Application No: FP/110/20/PL
Site Address: 82 Felpham Road Felpham PO22 7NZ
Description of works: Re-fenestration of shop front. This application may affect the character & appearance of the Felpham Conservation Area. This application is in CIL Zone 4 (Zero Rated) as 'other development'.

Thank you for your internet representation made on 21st July 2020 which has been recorded as no objection with the comments as follows:

Proposed Shop Front Refenestration
at 82 Felpham Road, Bognor Regis
for Mr and Mrs R Pearse
Drawing P02 July 2020 Scale 1:100
Proposed Drawing - Ground & First Floor / Roof Plan & Elevations

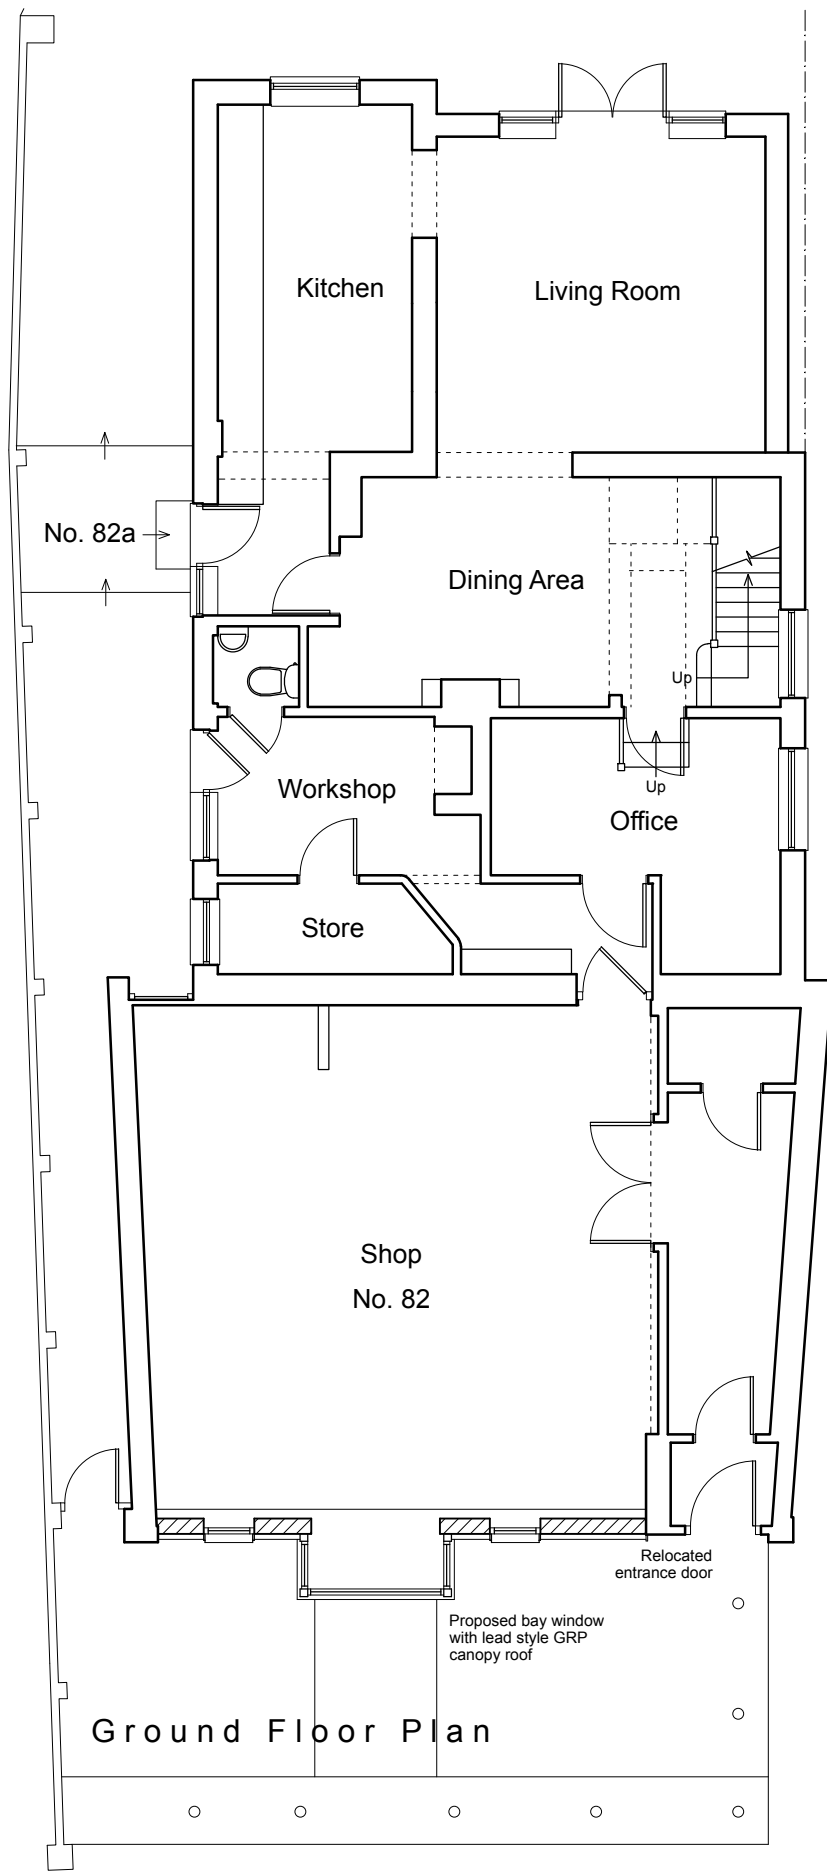
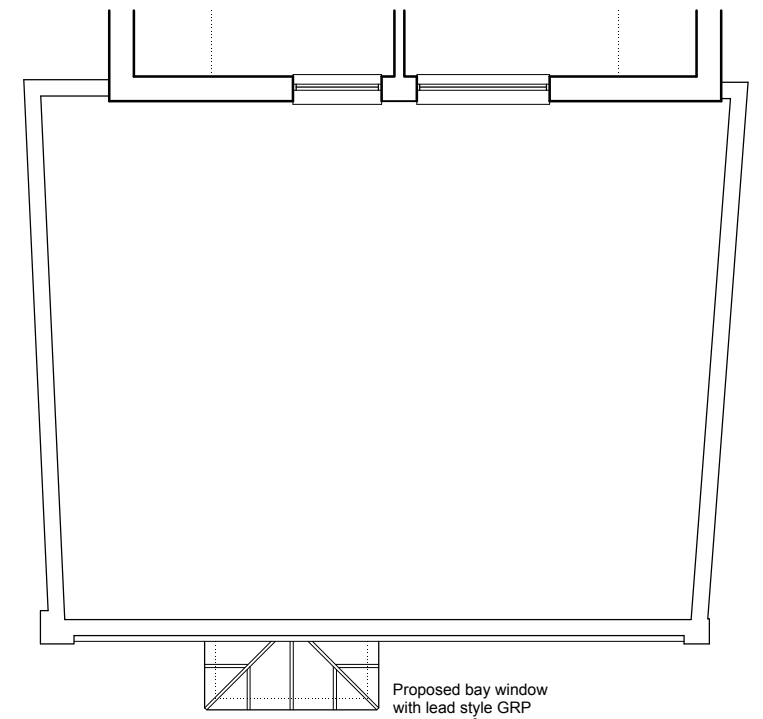
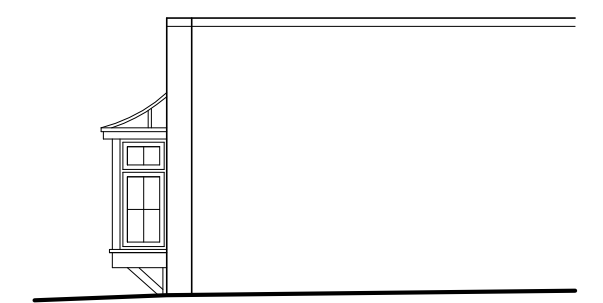
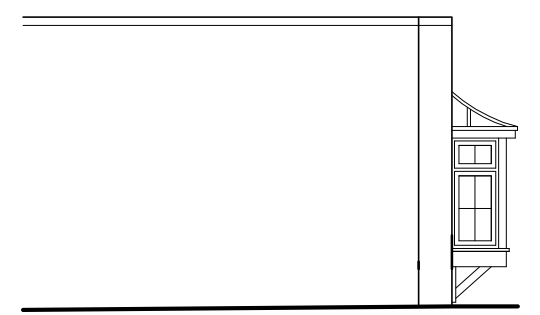
The proposed alterations provide an overall improvement in the appearance of the building but given the prominence of the new shopfront in the street scene and in views of the conservation area the use of painted timber for the fenestration and new door would be much more preferable than upvc (the intended use is indicated in the application form). Upvc will give over-bulky proportions to the framing. The use of powder coated aluminium of an appropriate colour for the shopfront could also be considered which would provide better proportions than upvc.

Details of the timber boarding in terms of its colour and profile need to be agreed at some stage.
